**From:** Sarah Fletcher <fletchsa1@gmail.com>  
**Sent:** Thursday, March 16, 2023 6:56 PM  
**To:** Ryan Harriman  
**Cc:** Suzanne Skone; Dan Thompson; Mike or Susie Cero; Carv Zwingle; Thomas Acker; Council; Traci Granbois; Robert Medved; Jessi Bon  
**Subject:** Re: Public Comments SUB 19-002/Boys and Girls Club Long Subdivision

2/16/23
JOB NUMBER: 13-118
SHEET NAME: RS-01
SHT 6 OF 9

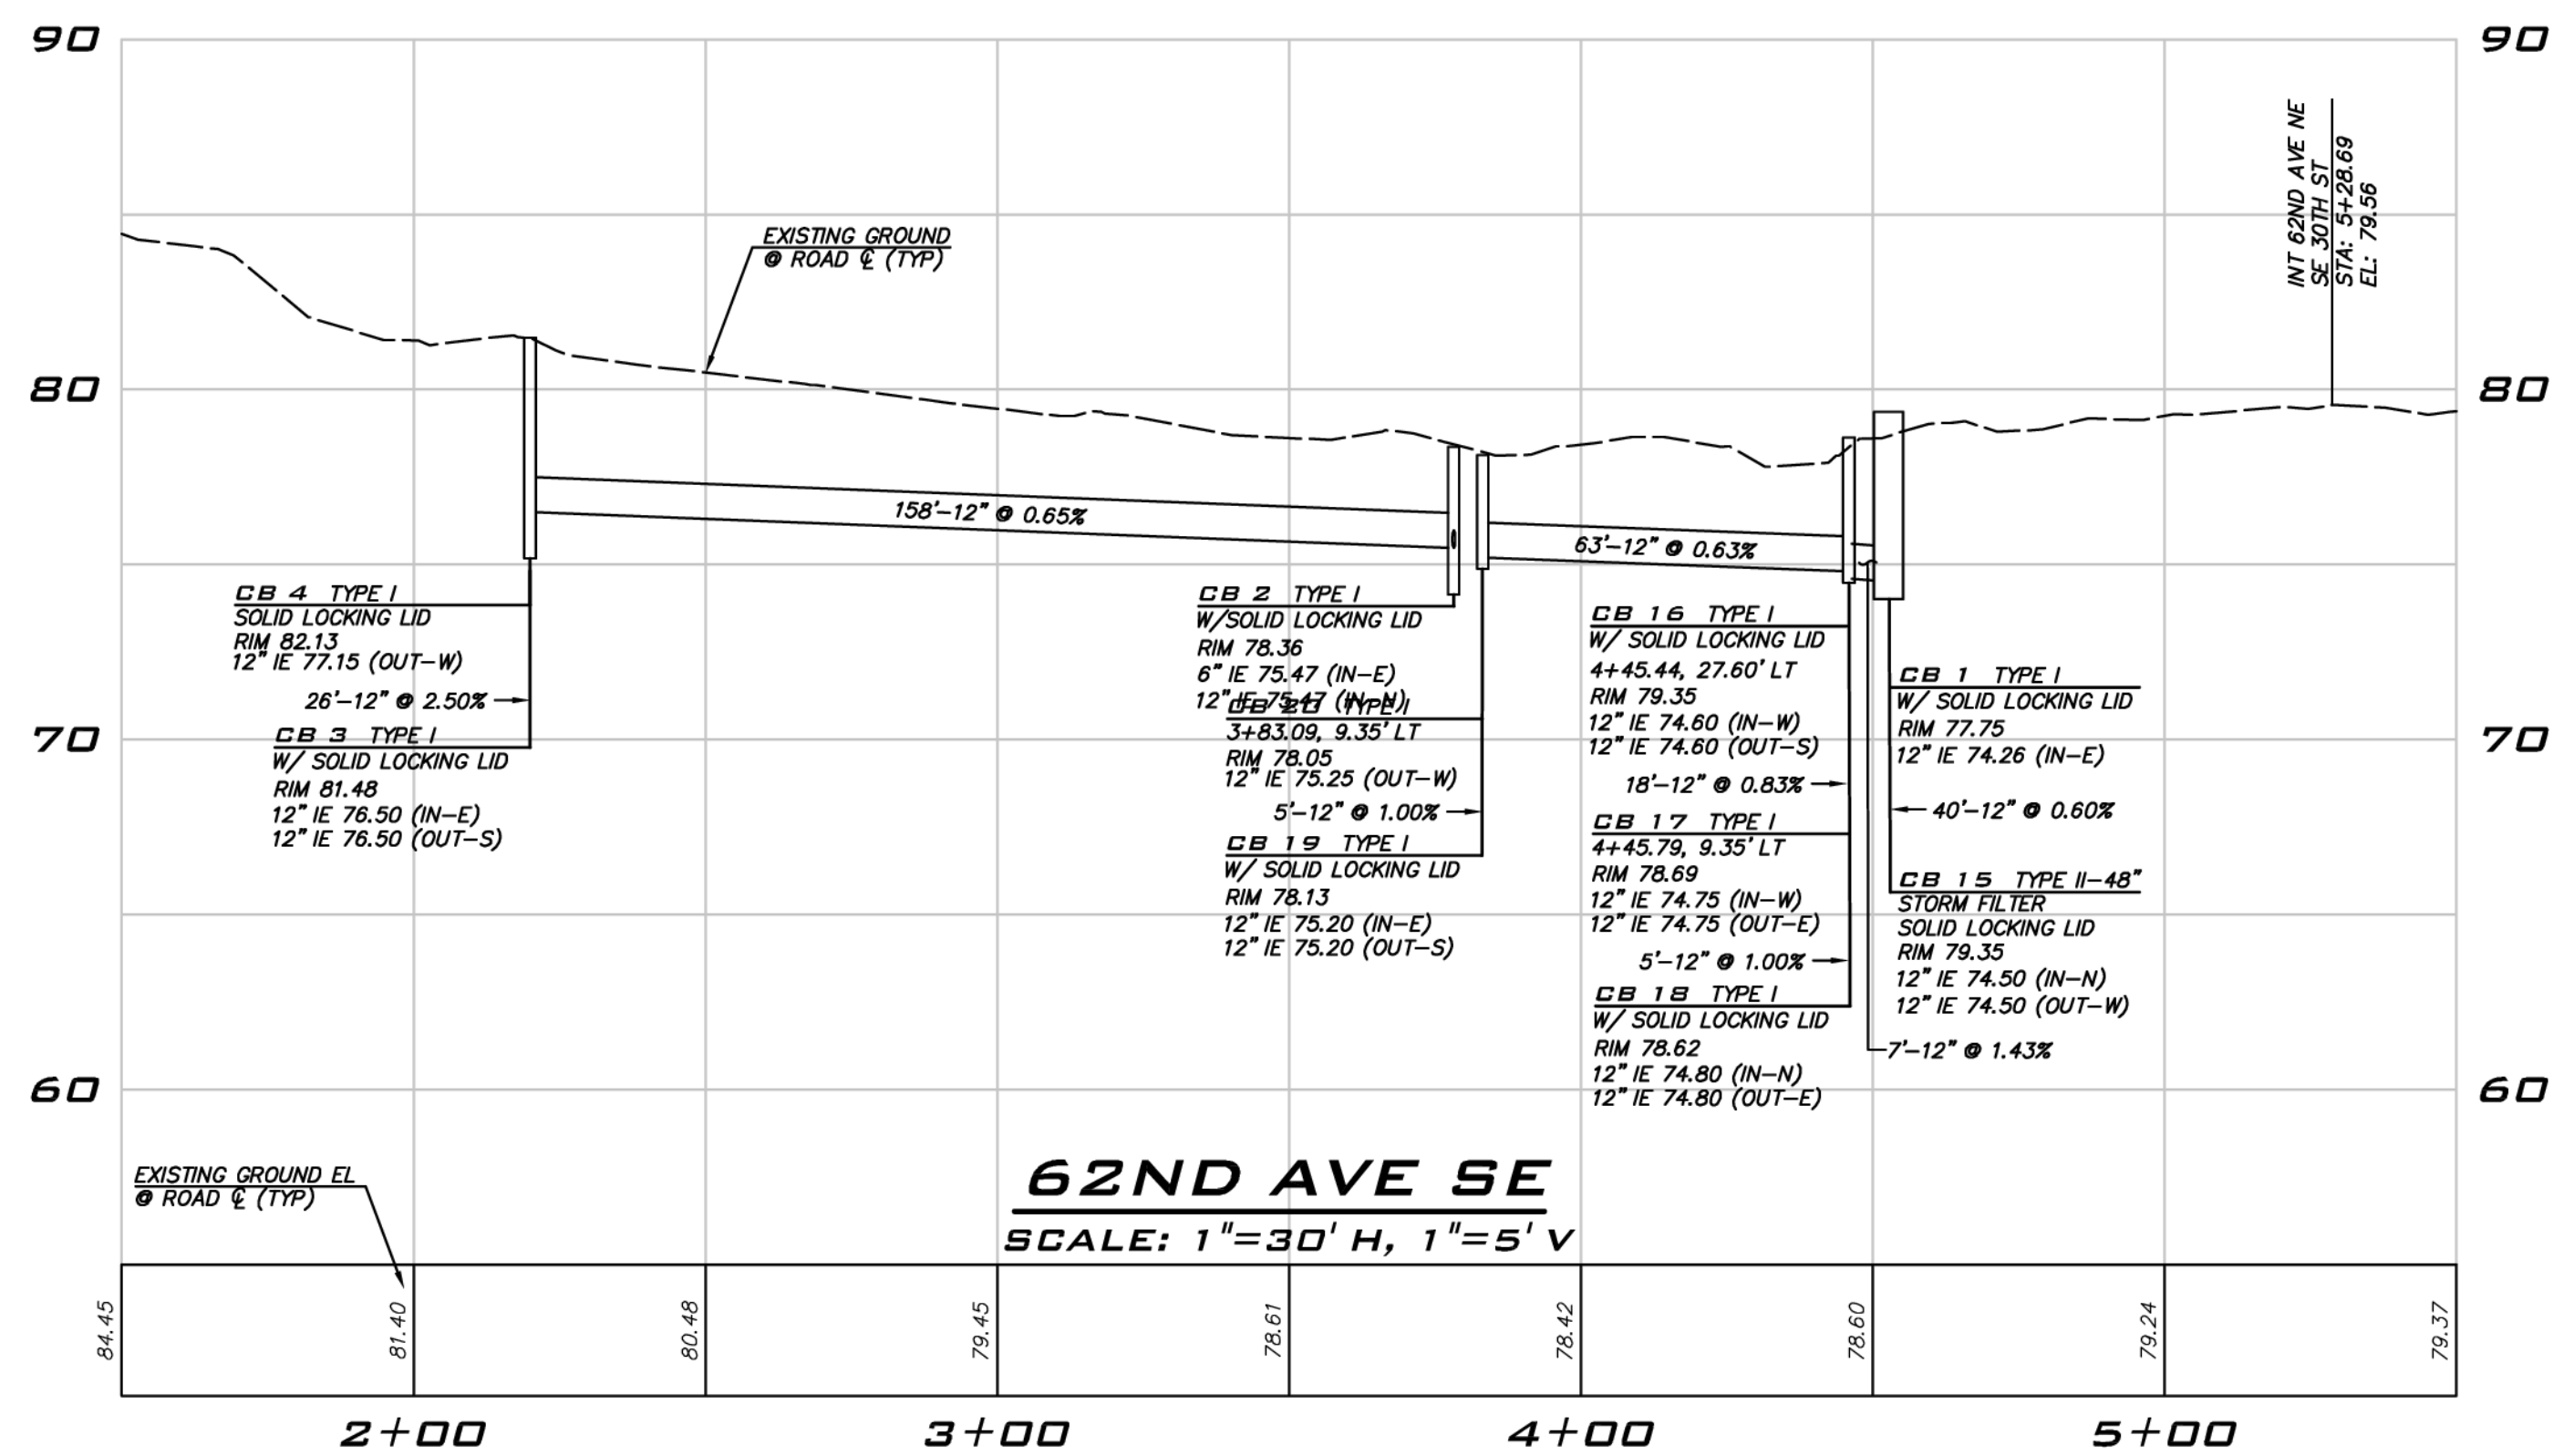
B. Ingress and egress should be by internal road for each house. The applicant no doubt does not like this since the internal road counts against lot area and lot coverage limits, but in my opinion the current plans are a danger to those walking or biking along adjacent streets. There is some internal access to some lots, but all access should be by an internal access road.
